Local Policing Support Team

Our Ref: NW/ARU/19/12A

RE: Land North of Mayflower Way, Angmering, BN16 4AY

Thank you for your correspondence of 23rd April 2019, advising me of an 'Erection of 24 No. dwellings with garaging & open resident & visitor parking with new access from Mayflower Way. Provision of hard & soft landscaping & open space, foul & surface water drainage systems & other associated works.' at the above location, for which you seek advice from a crime prevention viewpoint.

drawing  
CYCLE STORE

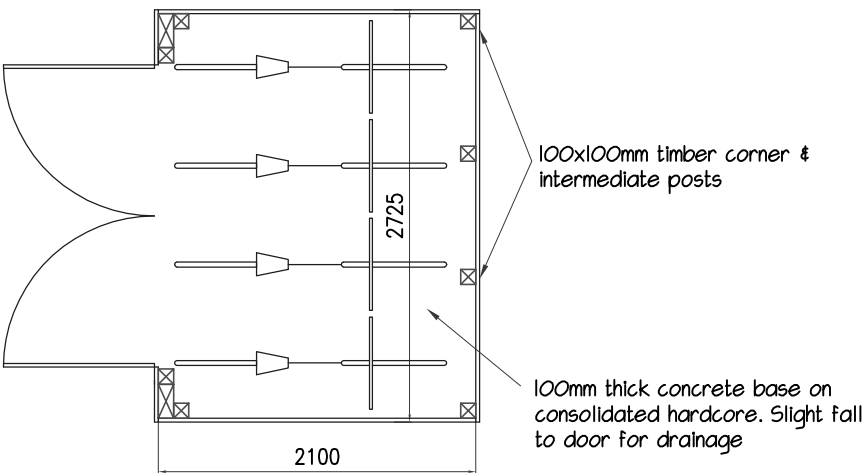
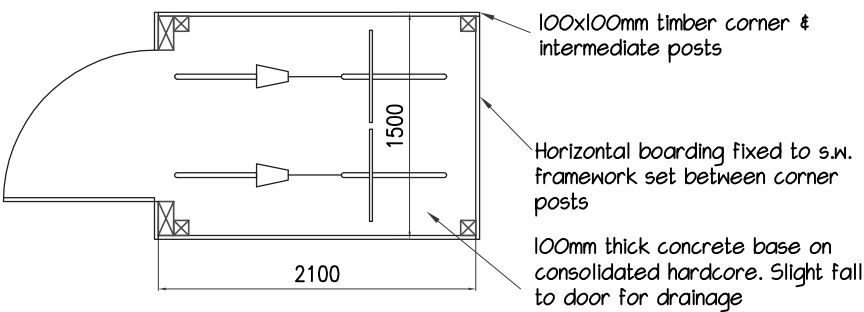
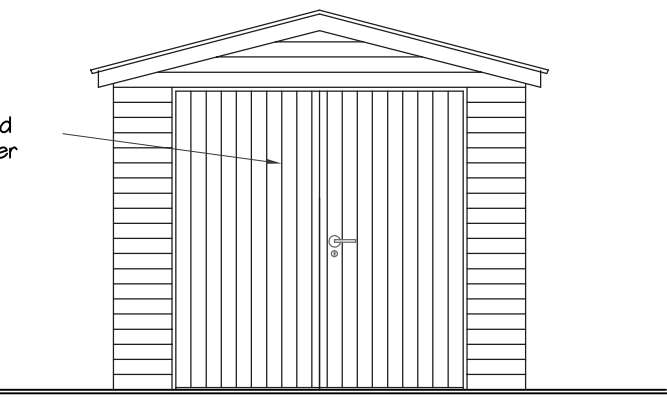
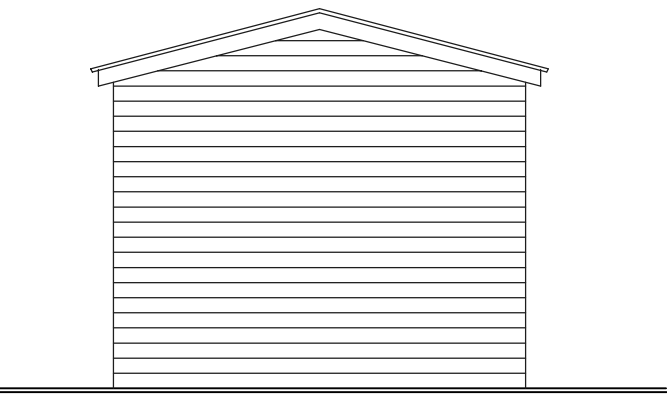
Paragraph's 56.1 to 56.57.3 of SBD Homes 2019 provides recommendations for secure bike storage,
